Design and Access Statement

76 Amberley Drive Hove BN3 8JP

Single Storey Rear Extension

Shape Architecture Ltd

PL001

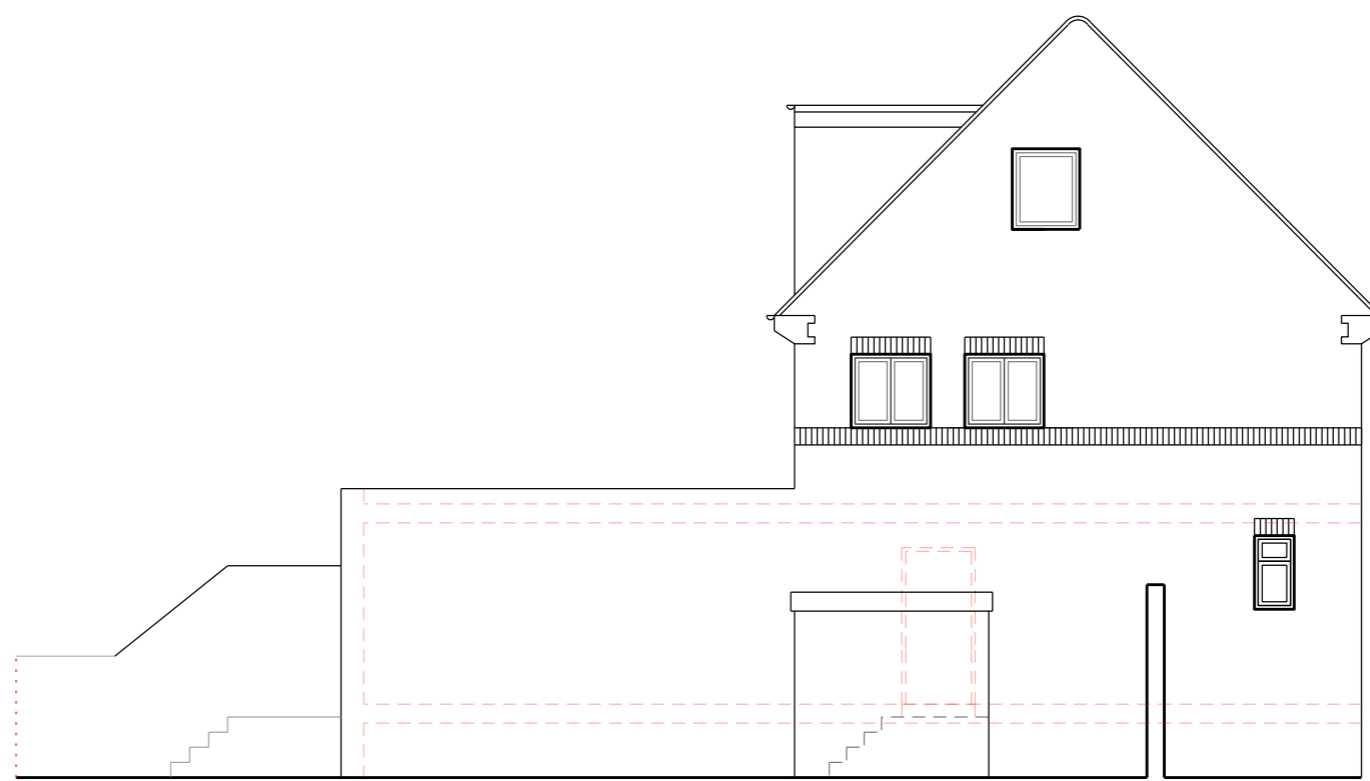
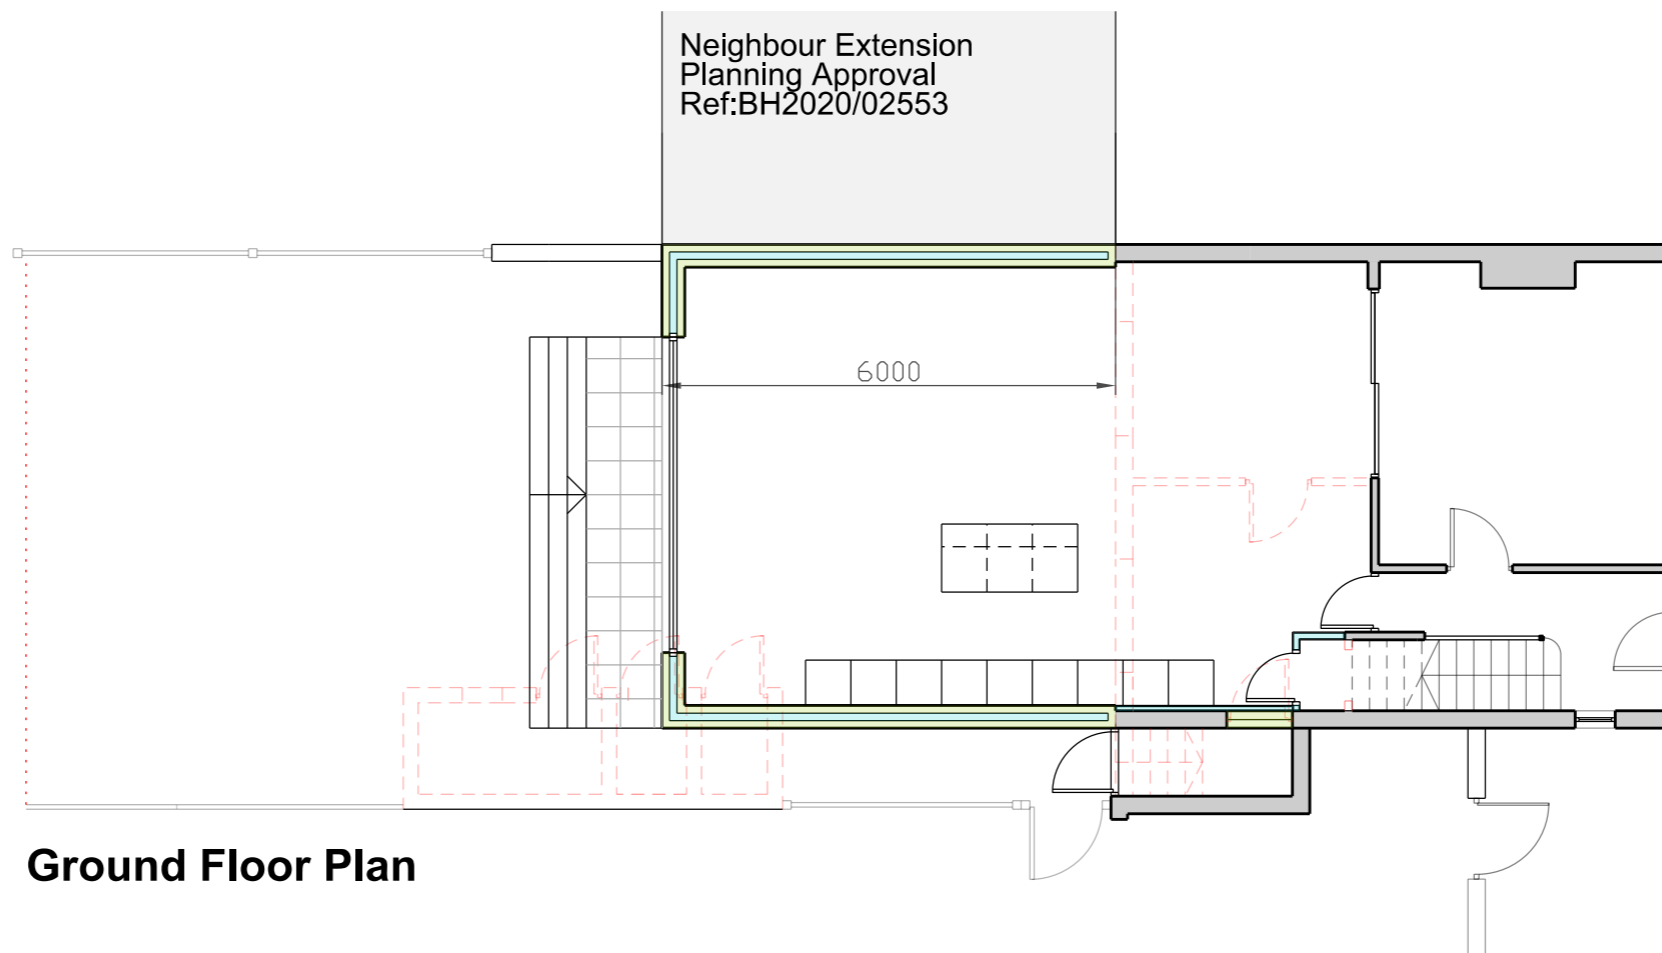
The proposed rear extension would have a depth of approx. 5.0m, a height of approx. 3.8m and a width equal to the existing building, and would be in brick to match the main house. A set of bifolding doors would occupy the rear elevation. The proposed rear extension would not fully accord with the design guidance set out in SPD12, as the extension would have a depth considerably greater than half the depth of the main house. Amendments may be sought to reduce the depth of the proposed extension accordingly. The proposed width, height, materials and detailing are likely to be considered acceptable in design terms.

The submitted drawings also show the creation of a terrace area at the rear of the proposed extension, an external store area at the side of the existing building, the raising of the boundary wall at the northern side of the garden and the demolition of the existing outbuilding on the southern boundary. The visual impact of these alterations would be assessed in full during a site visit as part of a future planning application, however based on the submitted drawings and information it is unlikely that any objection would be raised in design terms.

The proposed extension would be located adjacent to the boundary with the neighbour to the north, being built over the place of the boundary wall. This proximity to the neighbour, in combination with the 3.8m height and 5m depth of the proposed extension, is likely to result in overshadowing and other loss of light, in addition to an overbearing impact and increased sense of enclosure, for occupiers of the neighbouring property.

The proposed terrace area would have the potential to cause increased overlooking and noise disturbance for the neighbour. Whilst the proposed increased height of the boundary wall would likely mitigate potential overlooking, the potential increase in overshadowing and sense of enclosure resulting from the increased massing of the boundary treatment must be considered.

- 1. Reduce the depth of the extension to less than half of the depth of the existing building*
- 2. Reduce the height of the proposed extension*
- 3. Remove the proposed terraced area.*

The proposal projects 6 metres. We acknowledge the comment made in the historic pre-app but believe the situation is now altered with the granting of planning permission for 6 metre deep extension to number 78 next door.

The terrace also has a far reduced impact following the granting of planning permission for neighbouring extension. Nonetheless the terrace is pulled away from the boundary and shortened in depth.

As above, we acknowledge the comment made in the historic pre-app but believe the situation is now altered with the granting of planning permission for the 6 metre deep extension to number 78 next door.

The terrace also has a far reduced impact following the granting of planning permission for neighbouring extension. Nonetheless the terrace is pulled away from the boundary and shortened in depth.

As above, we acknowledge the comment made in the historic pre-app but believe the situation is now altered with the granting of planning permission for the 6 metre deep extension to number 78 next door in respect of each of the three points above. We also note changes to the terrace as noted above.
